Application No: AB/49/22/HH
Site Address: 31 Tarrant Wharf Arundel BN18 9NY
Description of works: Erection of single storey rear extension including the installation 2 x rear balconies and side rooflight and alterations to fenestration. This application may affect the character and appearance of the Arundel Conservation Area.

Thank you for your internet representation made on 20th May 2022 which has been recorded as an objection with the comments as follows:

DRAWING TITLE
 PROPOSED FLOOR PLANS,
 SECTION AND ELEVATIONS

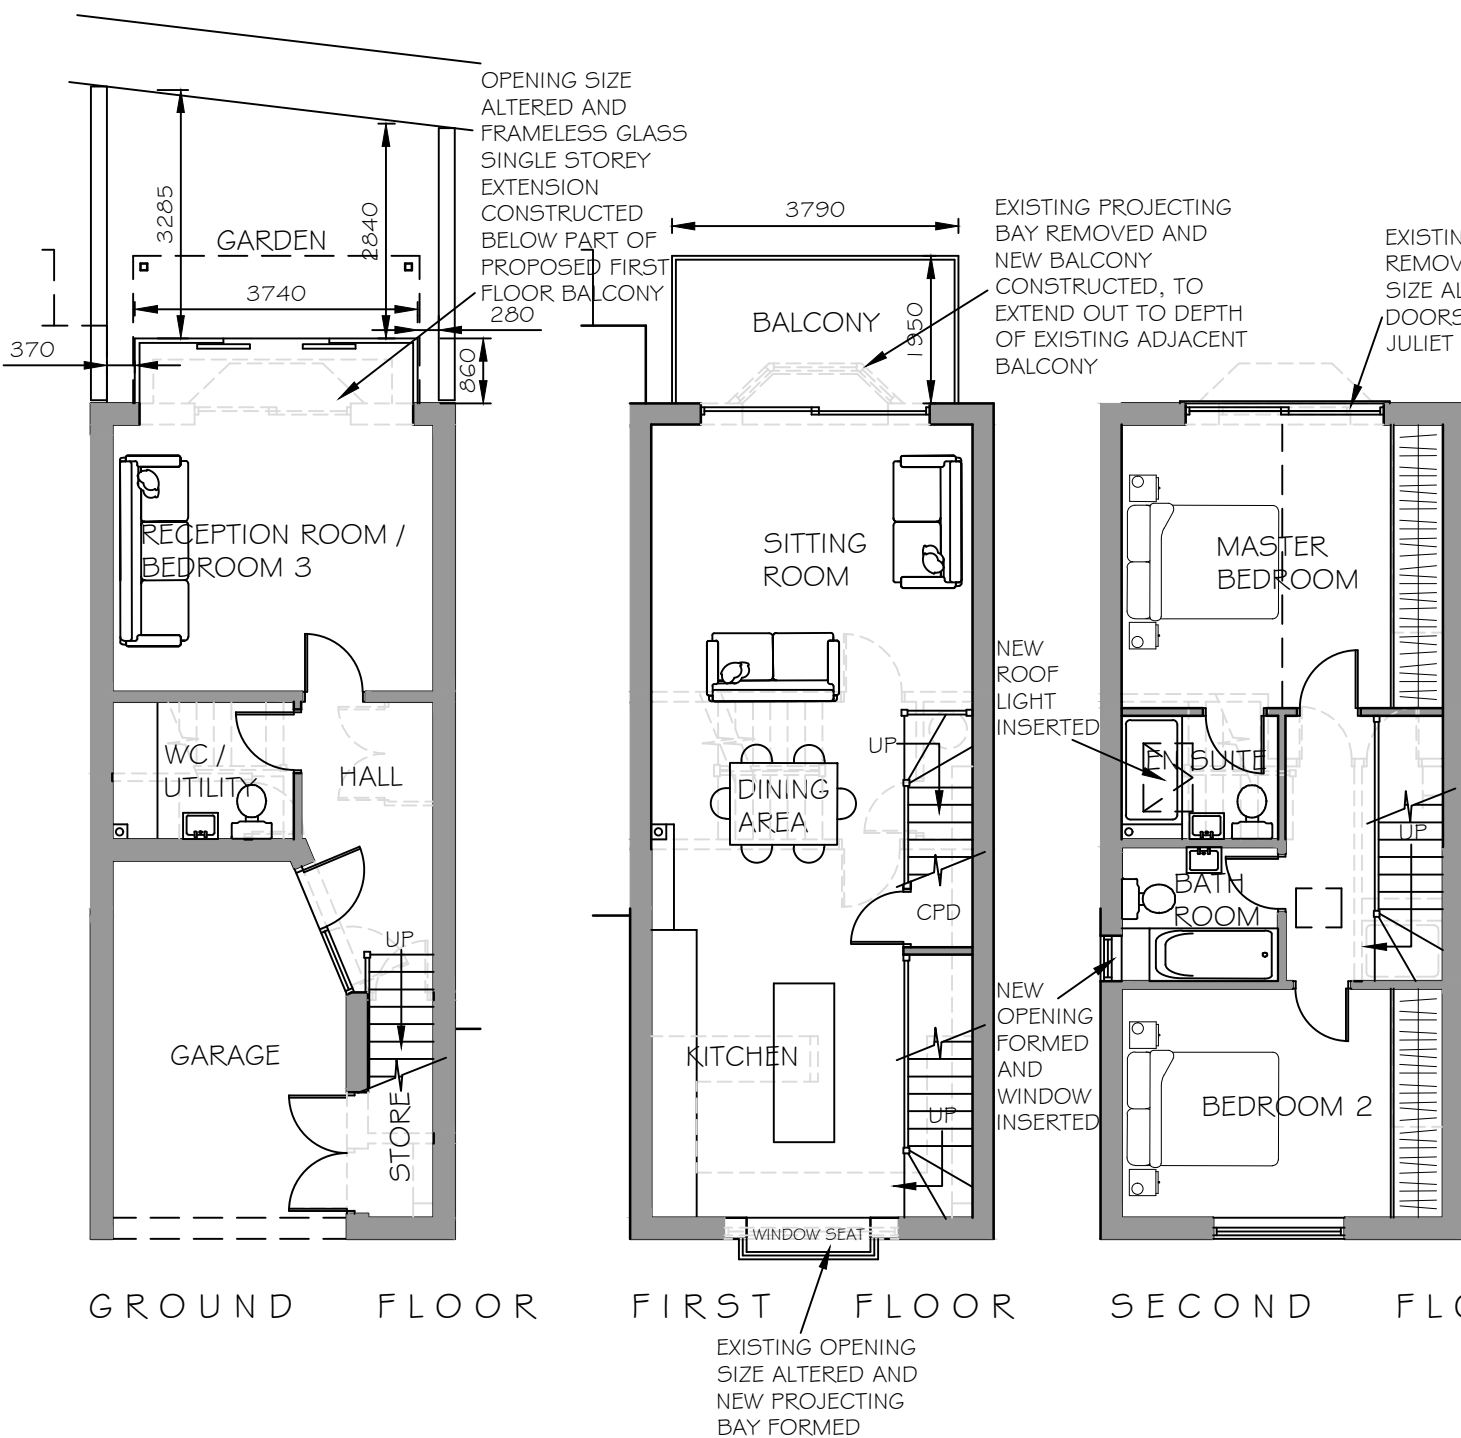
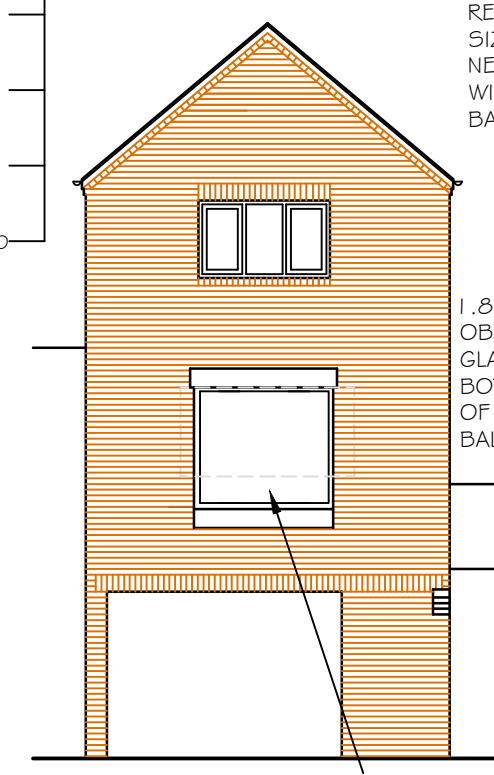
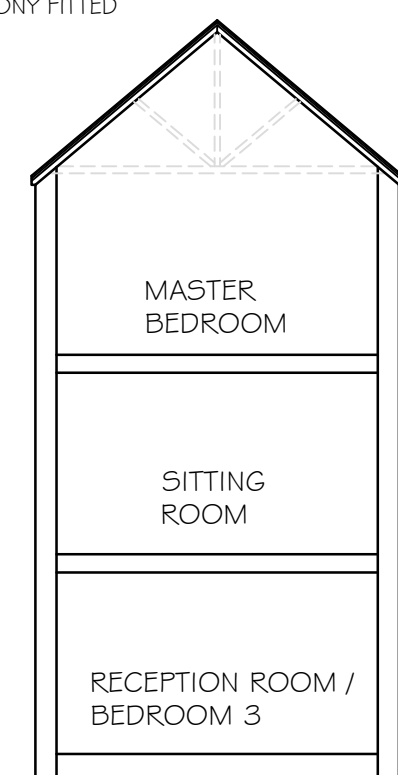
Living next door to proposed work, I object to the proposed rear 1st floor balcony extending by 1950 which will completely obscure my southern view of the river Arun from my lounge and balcony, reducing the amenity for me.
